## DECISION DELEGATED TO DEVELOPMENT MANAGER

**Application No:** H17-0575-20      **Applicant:** Mrs D Giessler

**Proposal:** Proposed extension and alterations - approved under H17-1072-15. Modification to Condition 2 to allow amendments to previously approved plans.

**Location:** 5 Low Gate Surfleet Spalding

OCT 2019 - 1:100, 1:50 & 1:1250 @ A2 - PLANNING DRAWING - GG/01 A

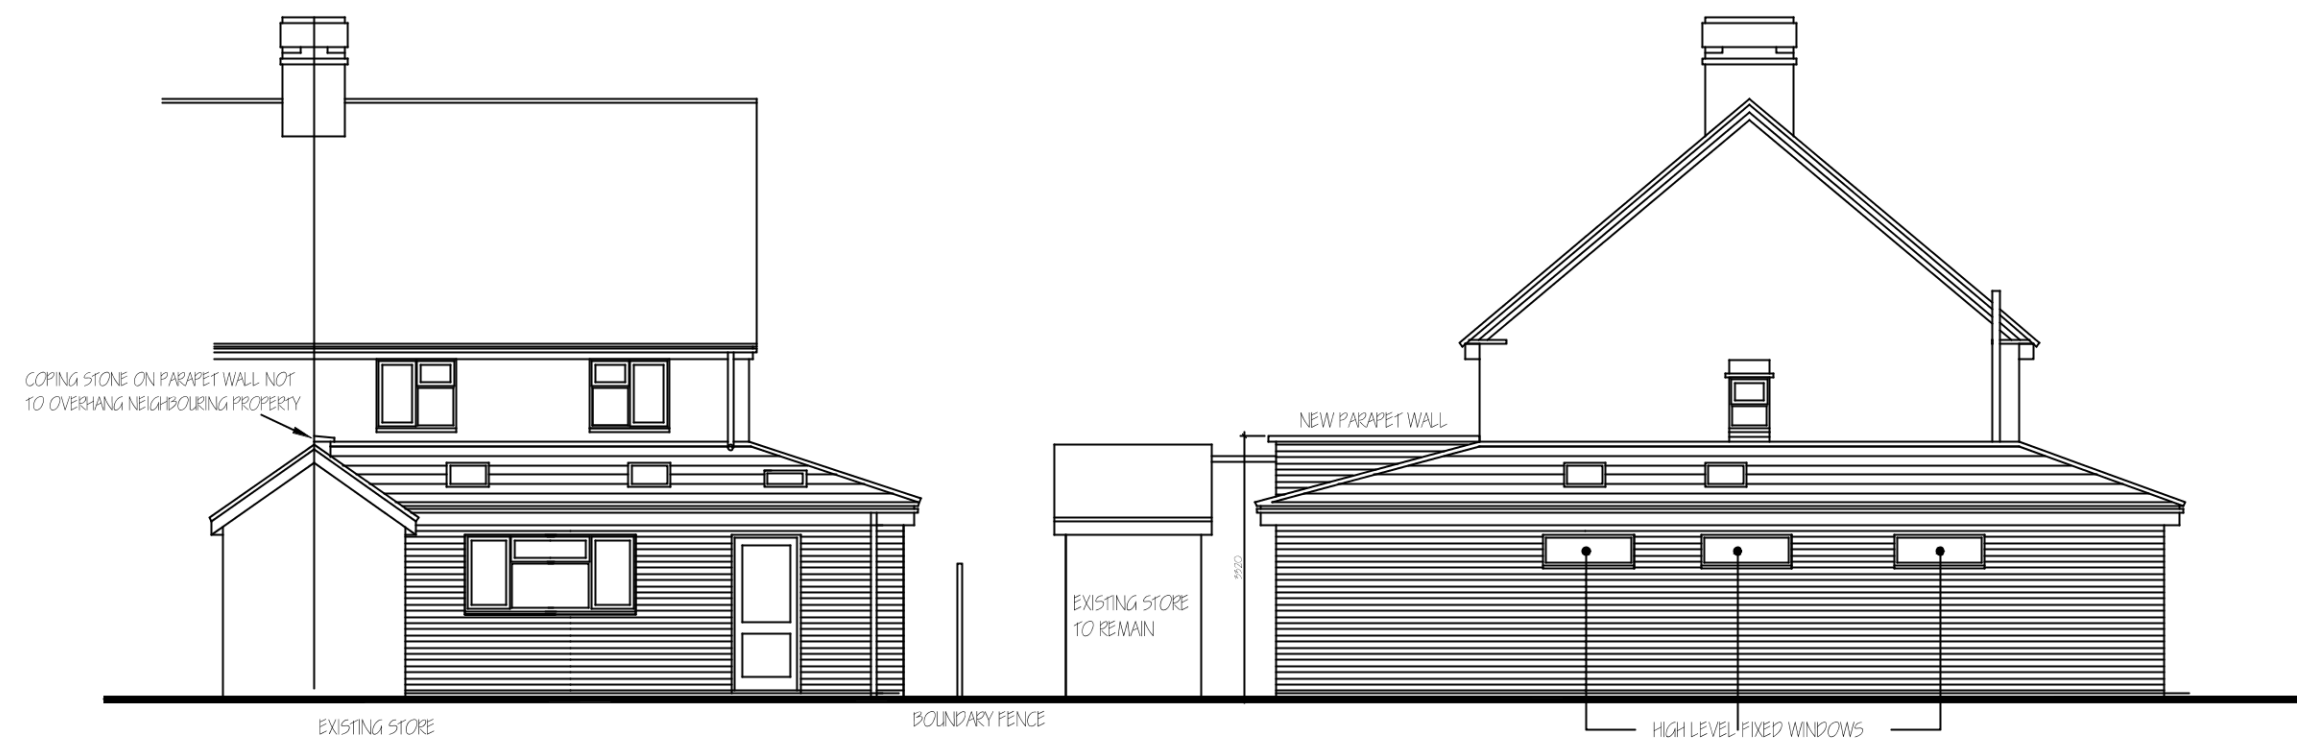
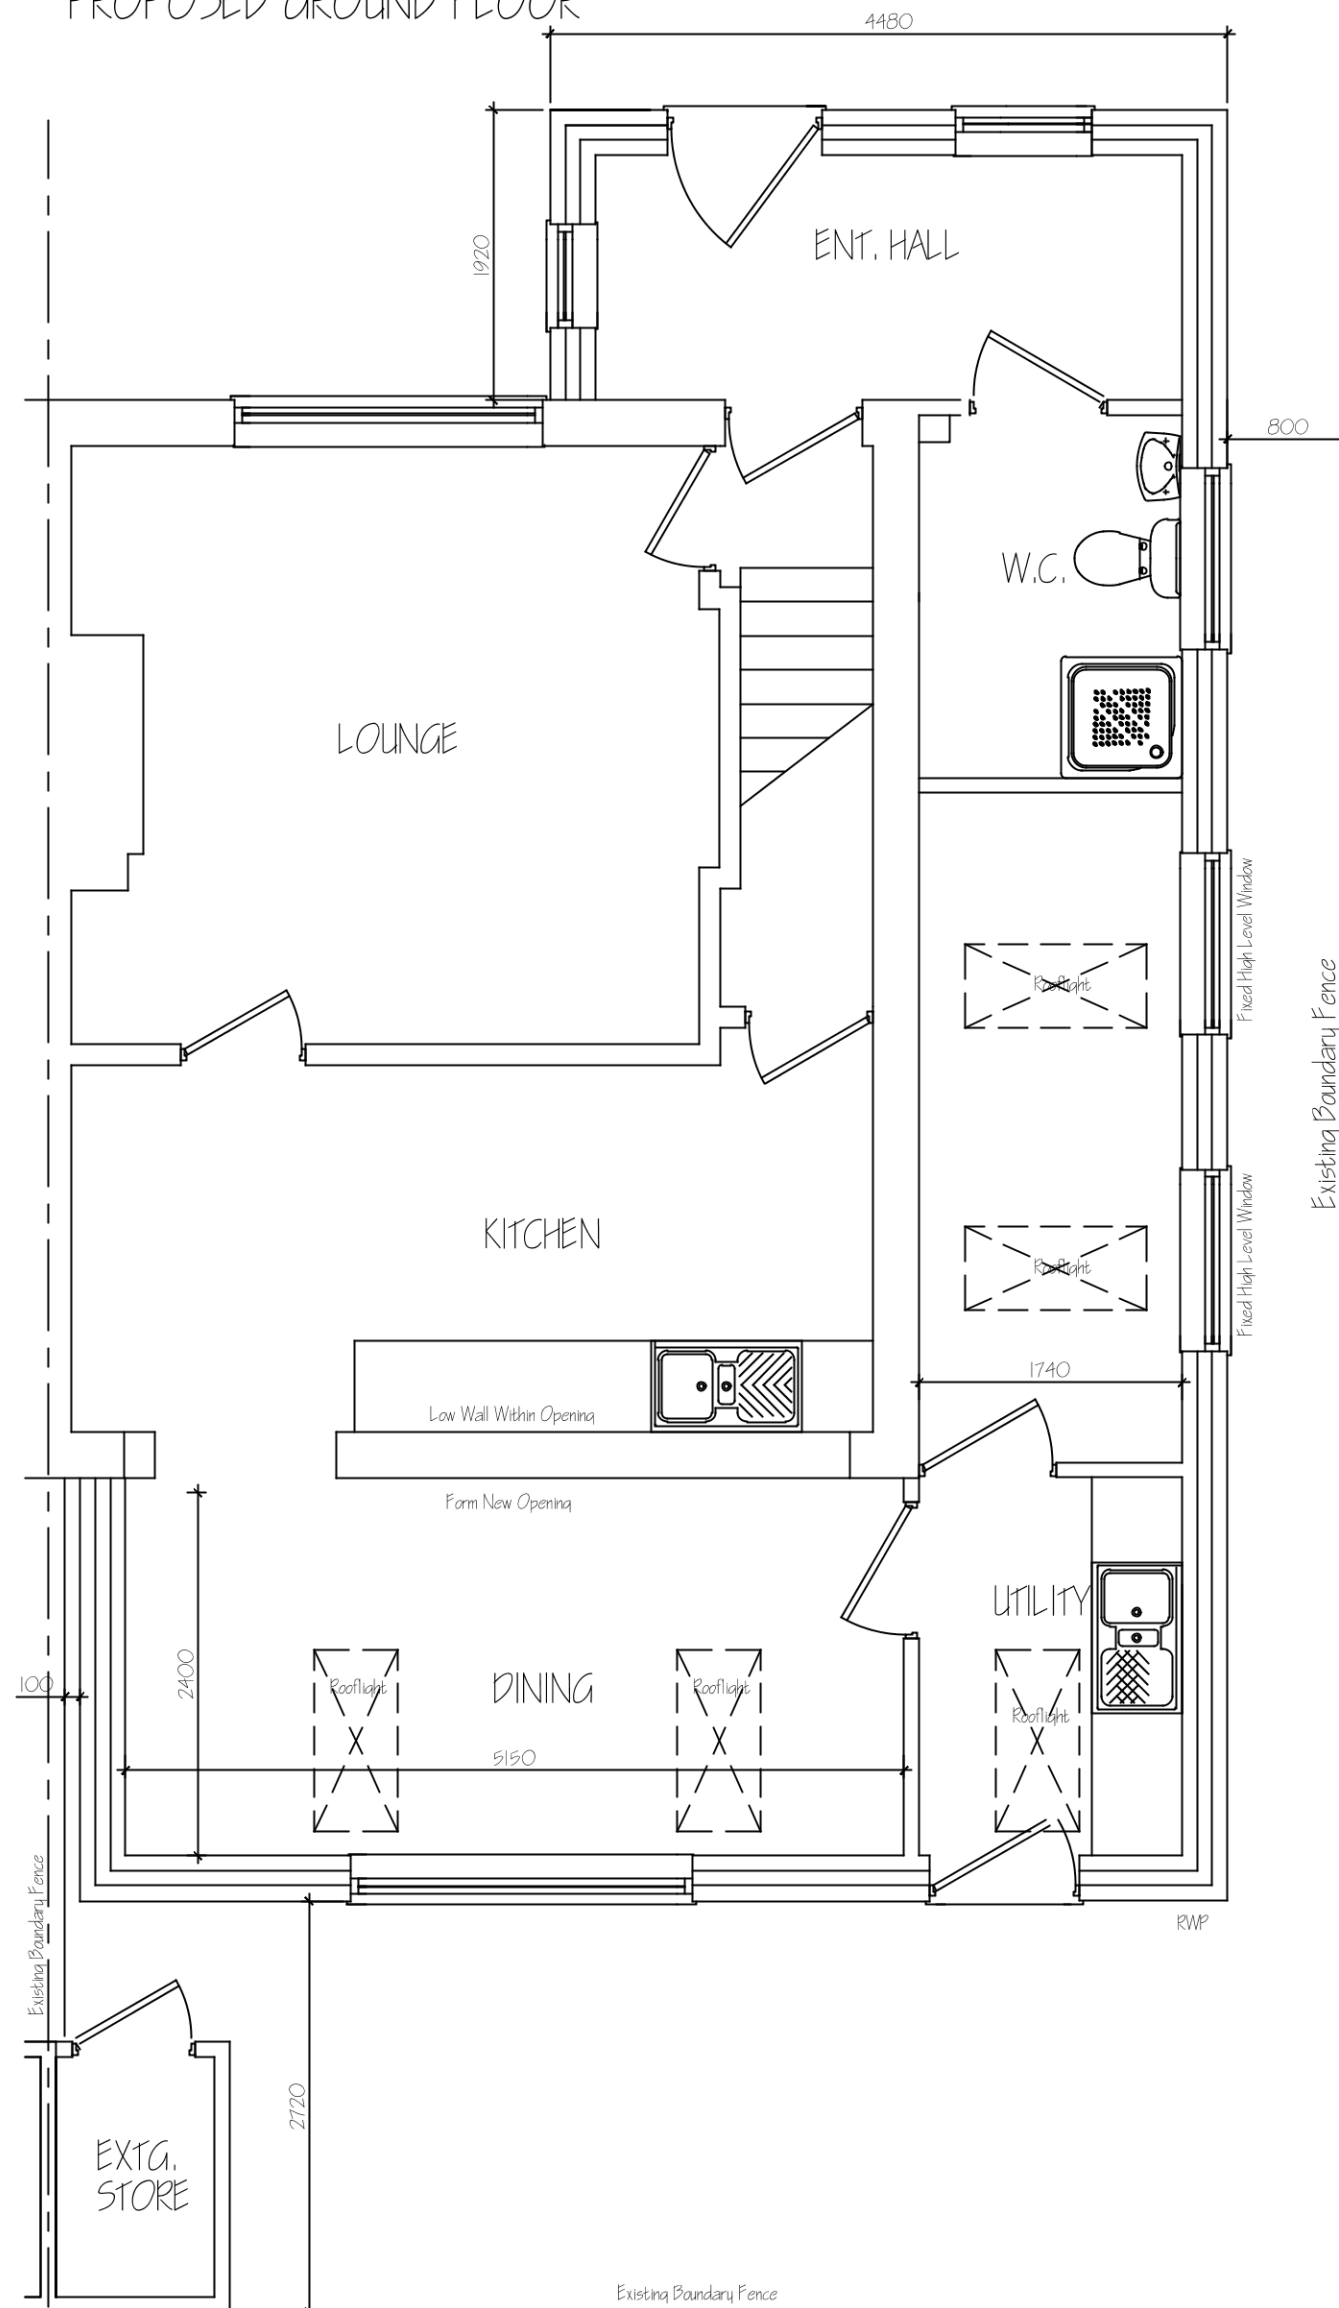
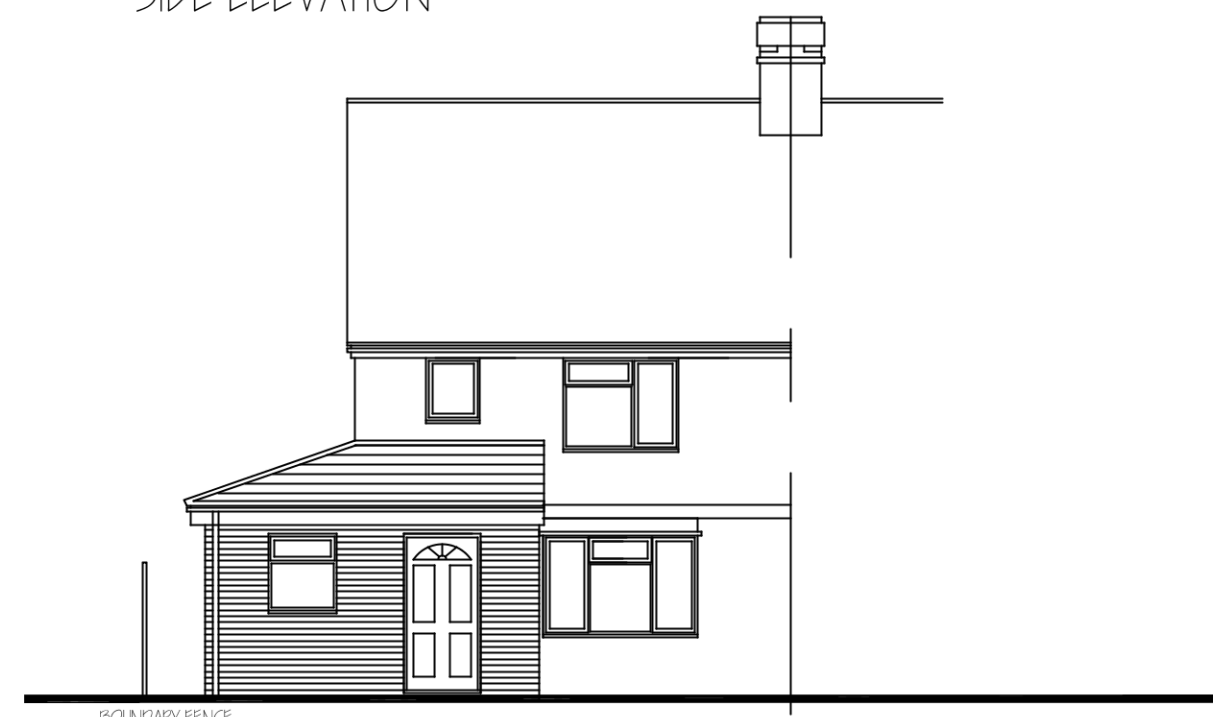
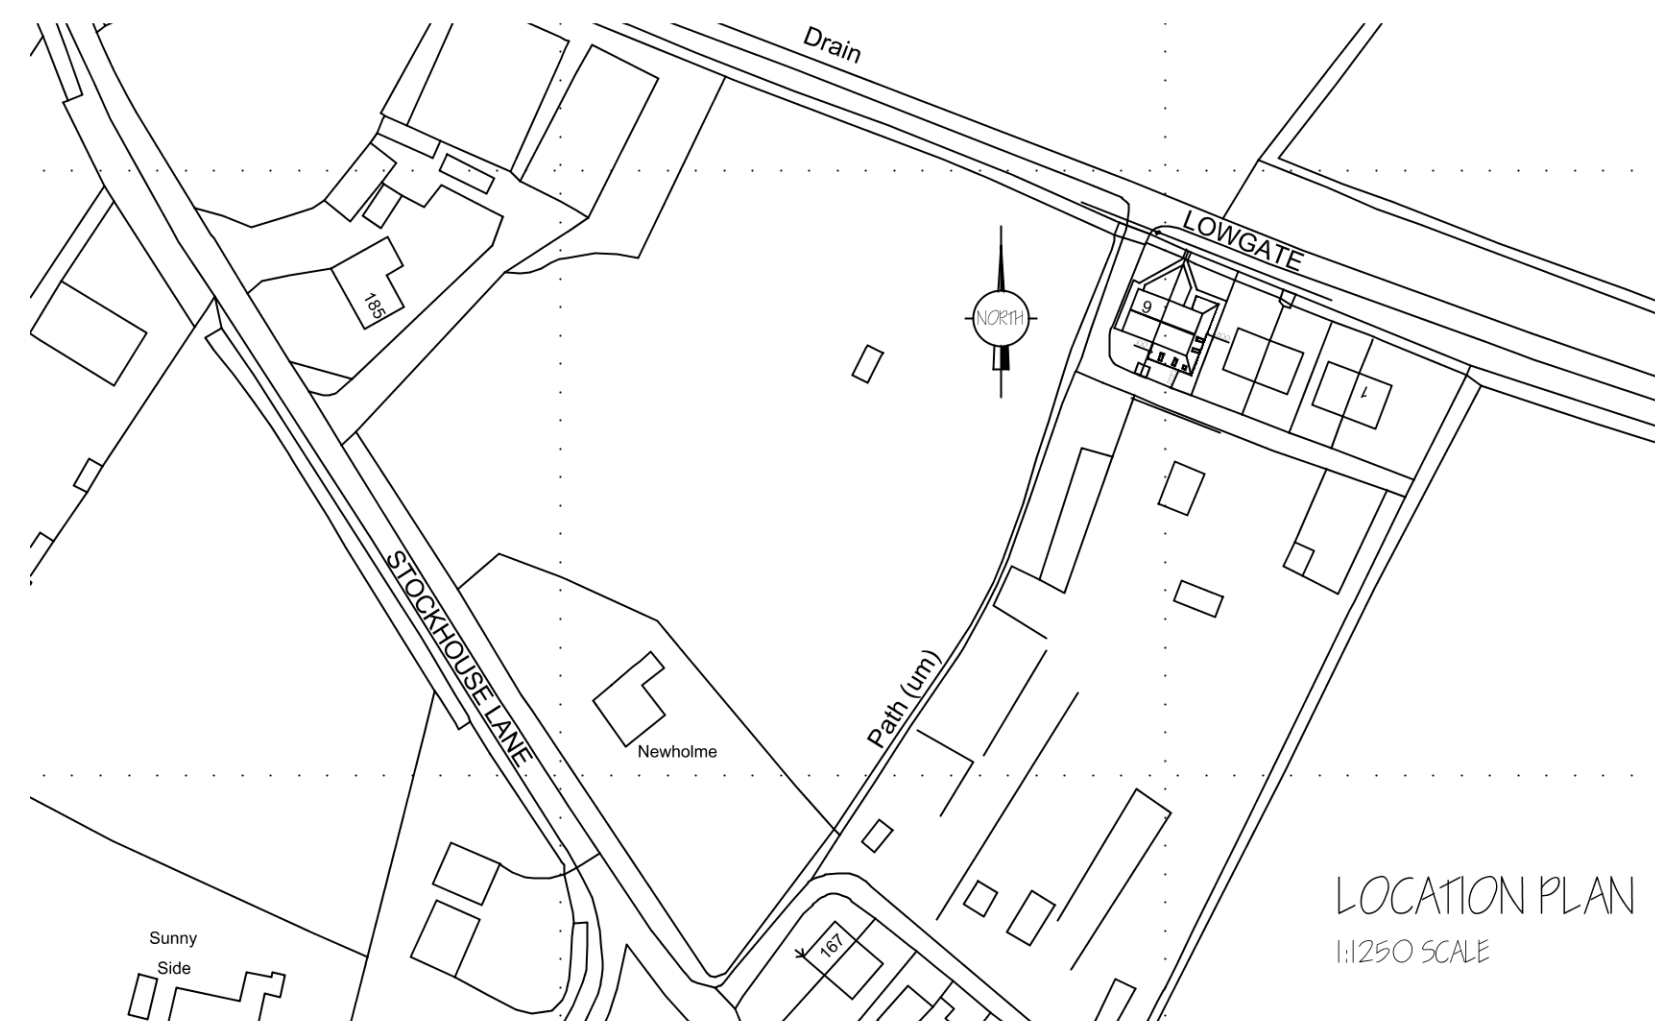
Questions why a parapet wall forms the boundary with 6 Low Gate and not a boundary fence.

The proposed parapet wall is not considered to impact the character of the development or the amenity of the neighbouring property at 6 Low Gate. Matters related to boundary ownership do not carry material planning weight and the wall is not sited on land or property in the ownership 6 Low Gate, according to the submitted plans. A coping stone on the original plans breached the line of ownership so amended plans have been received that bring the entirety of the development within the ownership of the applicant.
